REFERENCE	DE-2026/21
Date	30 March 2026

EXHIBITION OF STATE SIGNIFICANT DEVELOPMENT APPLICATION
CORRIMAL COKE WORKS – STAGE 2-4 EARLY STAGE (CIVIL WORKS)

Development	State Significant Development - Corrimal Coke Works – Stage 2-4 Early Stage (Civil Works) (SSD-86131212) - Request to Provide Advice on the Environmental Impact Statement (EIS)
Location	Lot 103 DP 1301632 Lots 3, 4 and 8 DP 1313981 Corrimal Cokeworks, Railway Street CORRIMAL NSW 2518

CORRIMAL COKE WORKS
STAGE 2-4 RESIDENTIAL SUBDIVISION
CIVIL WORKS
LAYOUT PLAN

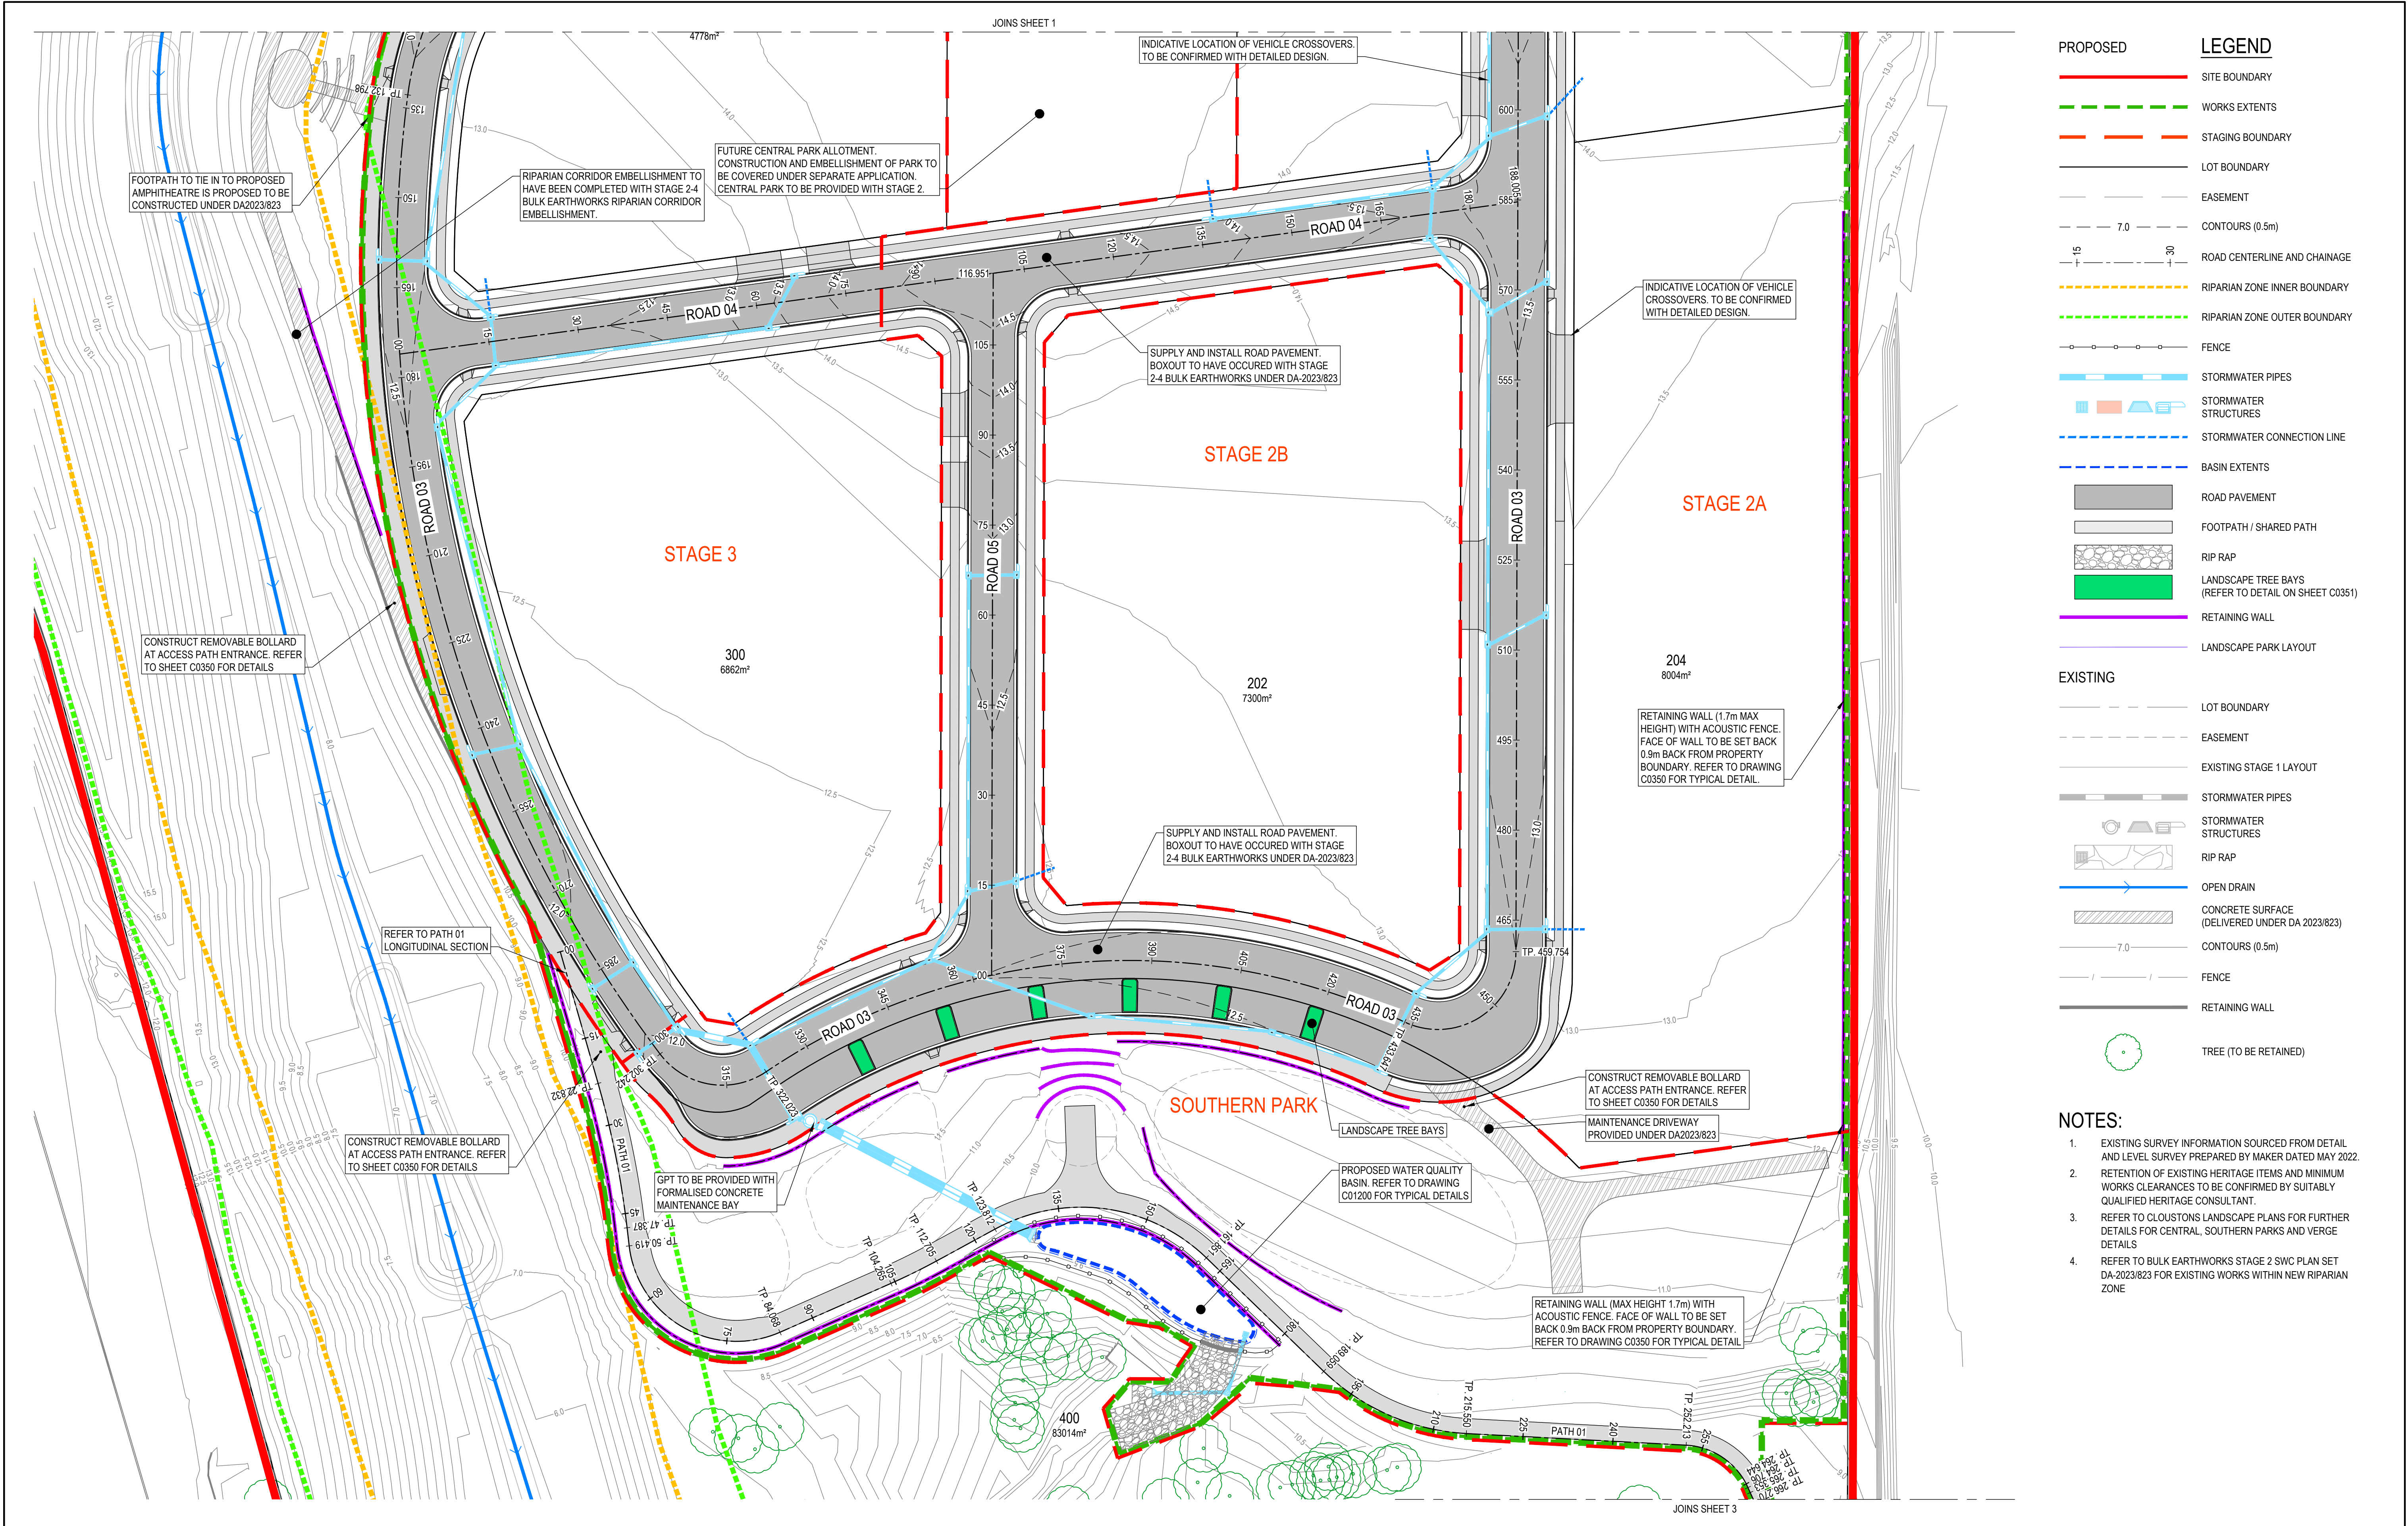
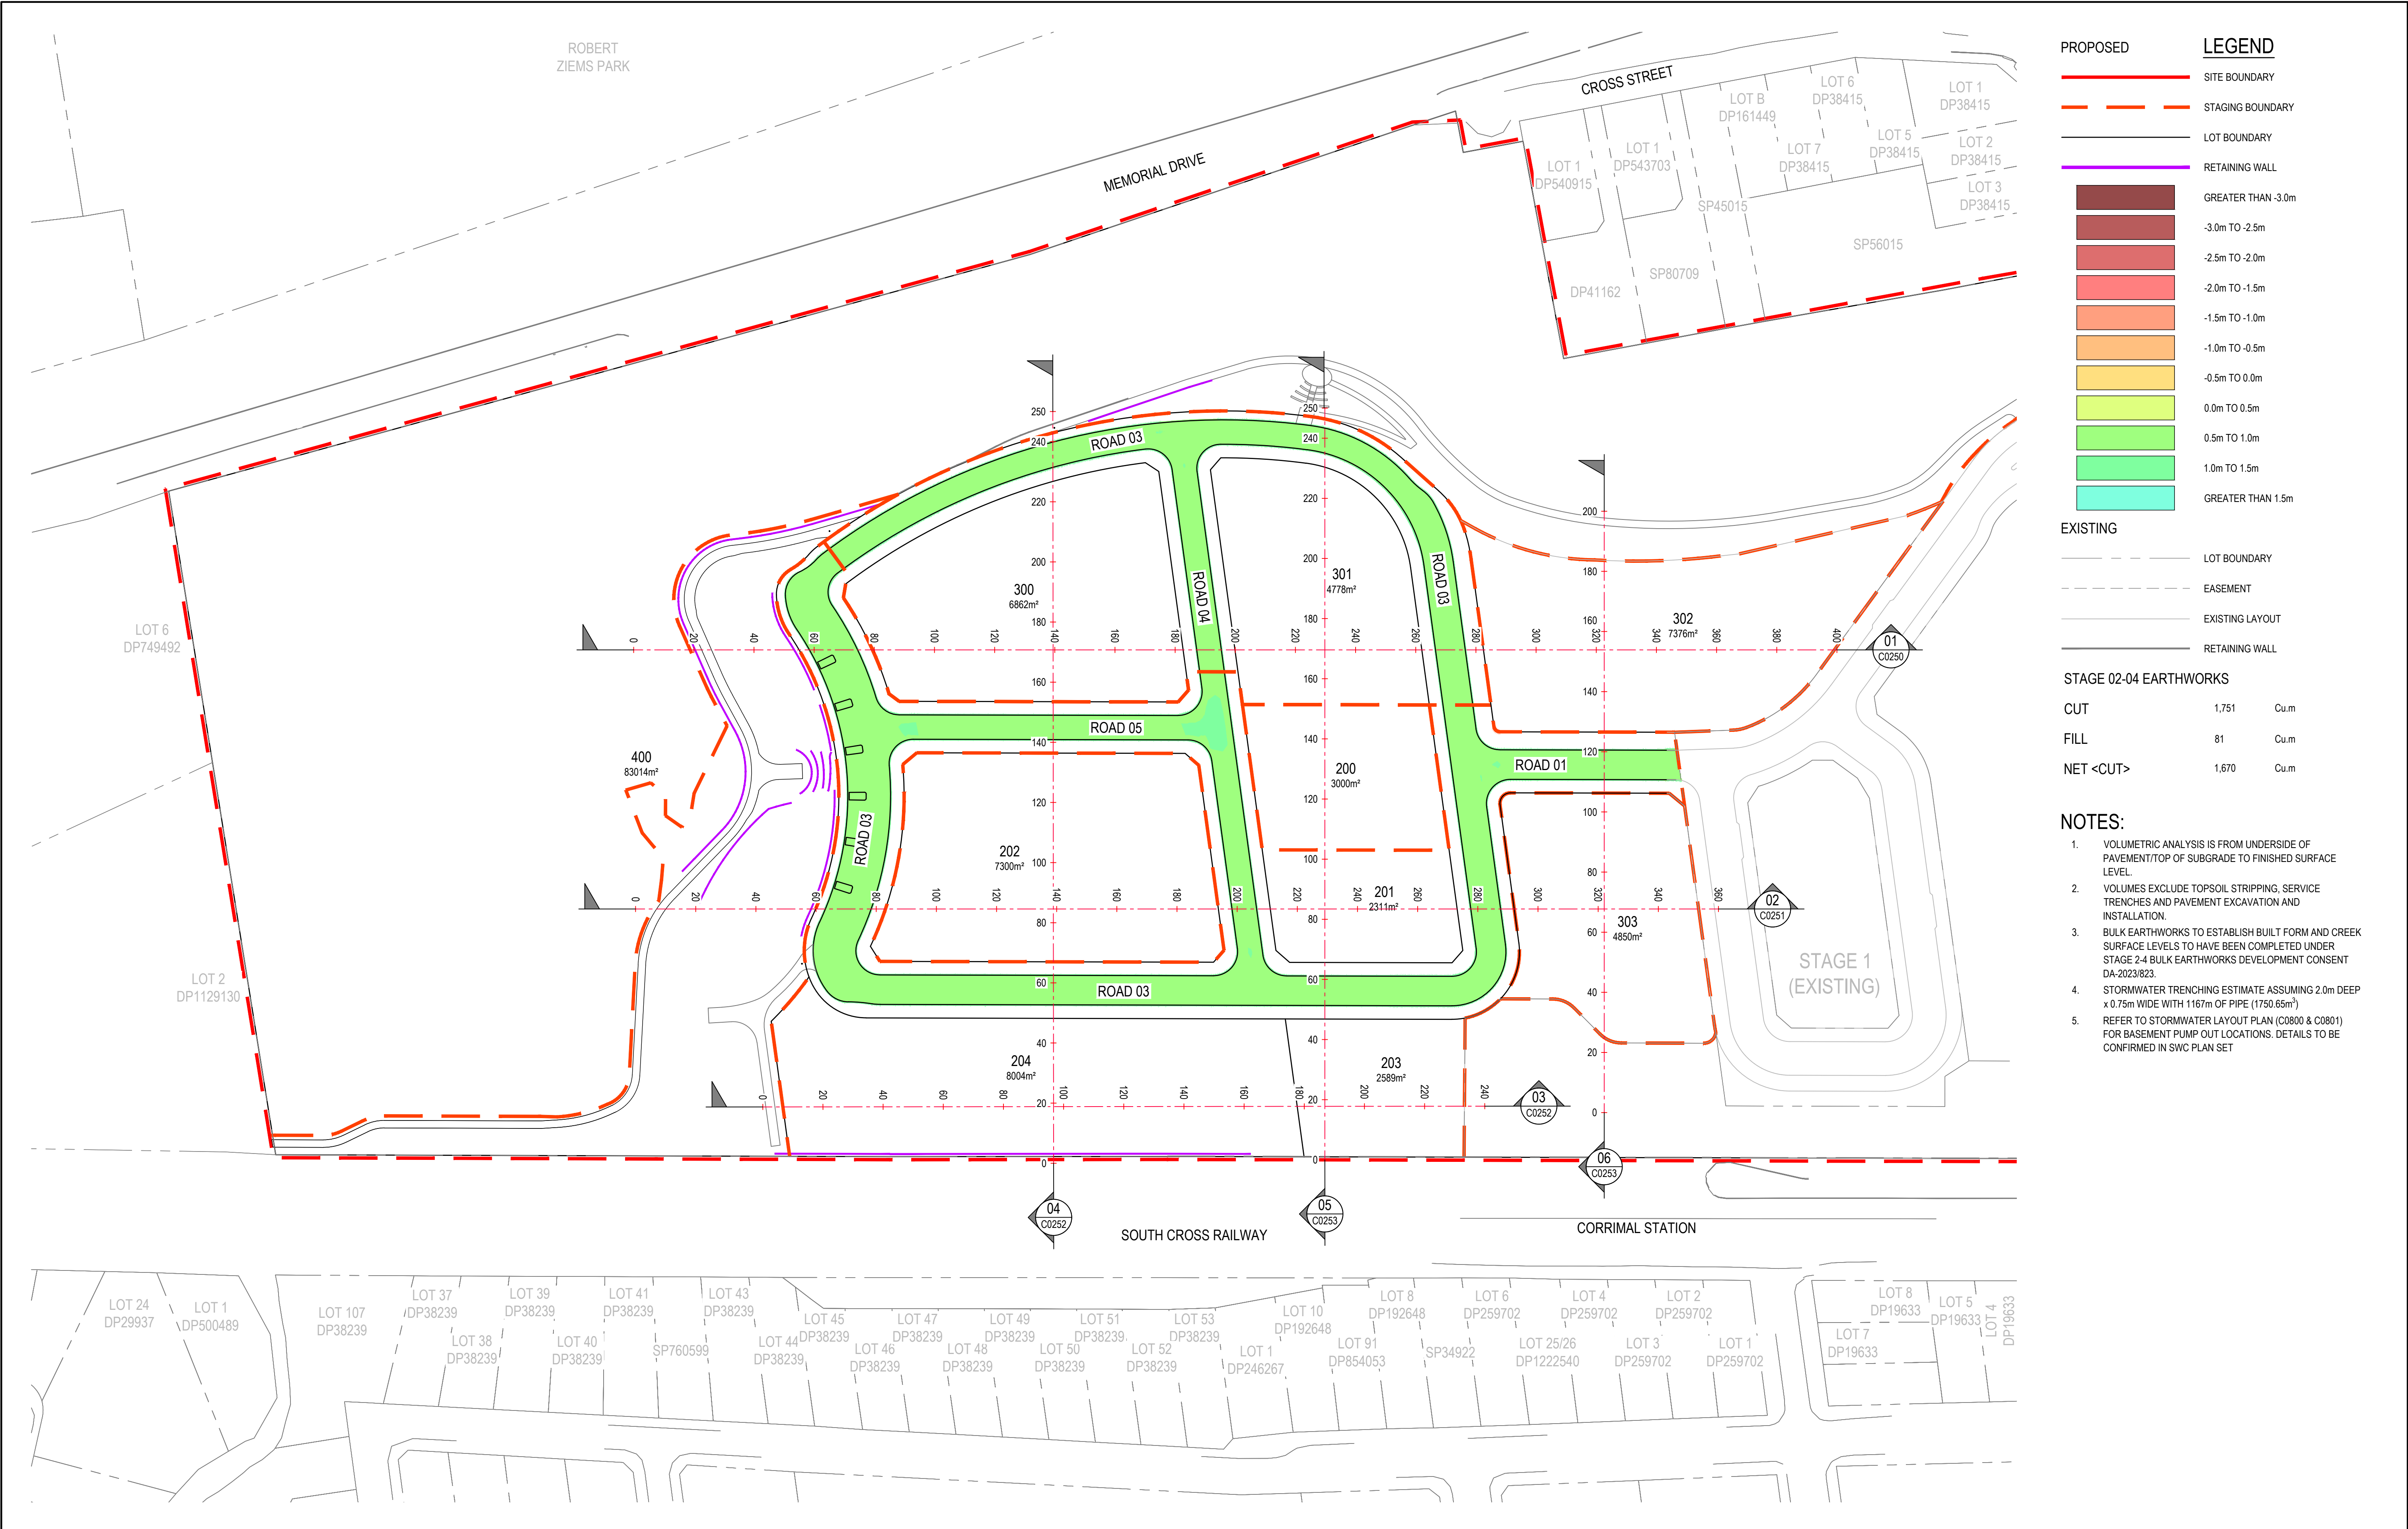
- Shared paths away from the public roads must demonstrate adequate clearances to any solid obstructions as per the requirements of Austroads and if there is a drop-off from a raised section of path, barriers would be required which may need additional widening to ensure adequate clearances to bicycle handlebars.
- Signs and Lines (proposed timed parking, no stopping etc.) will need to be submitted to the Wollongong City Council Local Transport Forum for consideration by the technical committee prior to approval by Council.
- It is noted that several intersections are lacking pram ramps on some corners. All corners of intersections must have pram ramps for pedestrian connectivity and permeability throughout the site.
